PLANNING APPLICATION R/31/26/HH: 15 EVELYN AVENUE BN16 2EJ

ANNEX to 19 March 2026 letter

Planning Application R/31/26/HH: Comments on Planning Statement

Proposed Roof Plan
1:200 @ A3

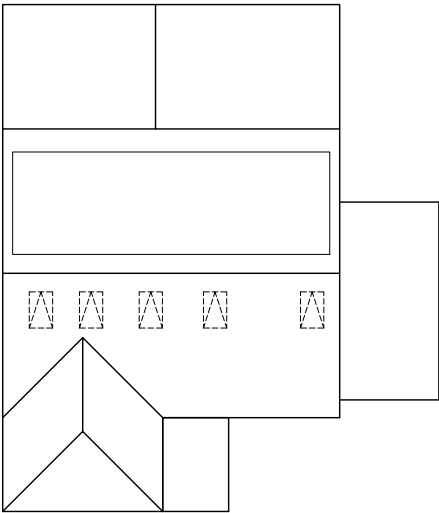
- b. that it includes an oversized dormer with windows that will closely overlook other properties' rear gardens with consequent loss of privacy;
 - c. that it is out of keeping with the properties in this part of Evelyn Avenue visually and in its size and extensive use of cladding;

Rev	Notes	Date
 M: 07599199759 E: info@nat-design.co.uk www.nat-design.co.uk		
Project:		
15 Evelyn Avenue Rustington BN16 2EJ		
Drawing:		
Proposed Elevations		
Drawn by NSE		Scale as shown
Date Feb 2026		Revision
Drawing		
2027 - DPA - 06

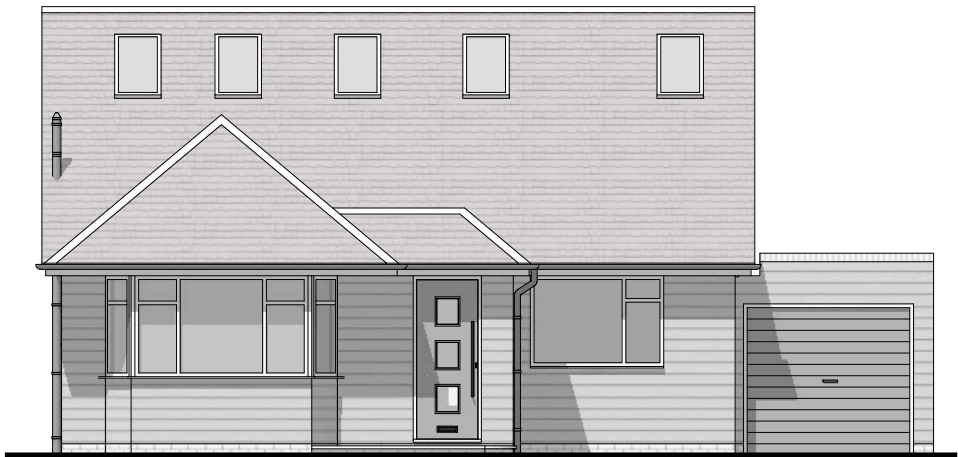
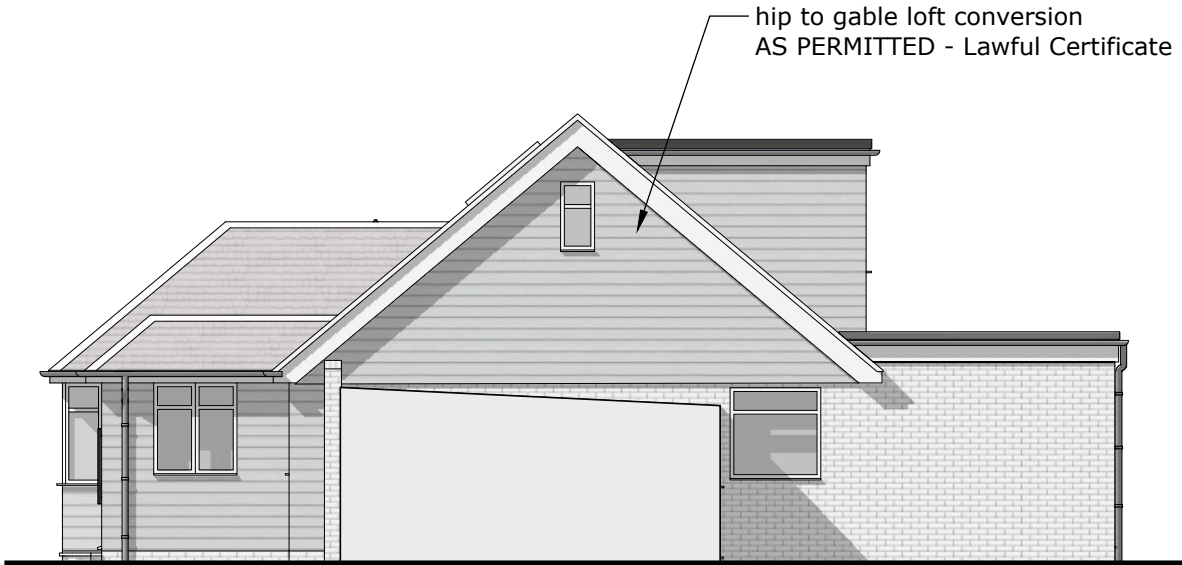
4. The street scene would be ruined by the mass of No 15, with the new breadth of its steep roof and the extensive use of cladding. The main body of Evelyn Avenue is of single storey properties and Nos 15 and 17 are in the middle of a row of ten (Nos 7 to 27) originally identical 1950s bungalows that remain of uniform appearance. Although there are some properties of other types in Evelyn Avenue these are at the ends of the road and on suitable plots. The justification for the cladding, ie that it is used elsewhere in Evelyn Avenue, is misleading. There is no cladding on our row of ten bungalows. Only five properties in the road have any cladding, all limited to infill on the gable ends of bungalows. This, therefore, would be the only one to have so much cladding and would be totally out of keeping.

5. Also the lawful development (R/6/26/CLP) for the loft extension was decided (on 12 February 2026) on the basis of tile hanging rather than cladding, though the plans submitted with this application do not show that.
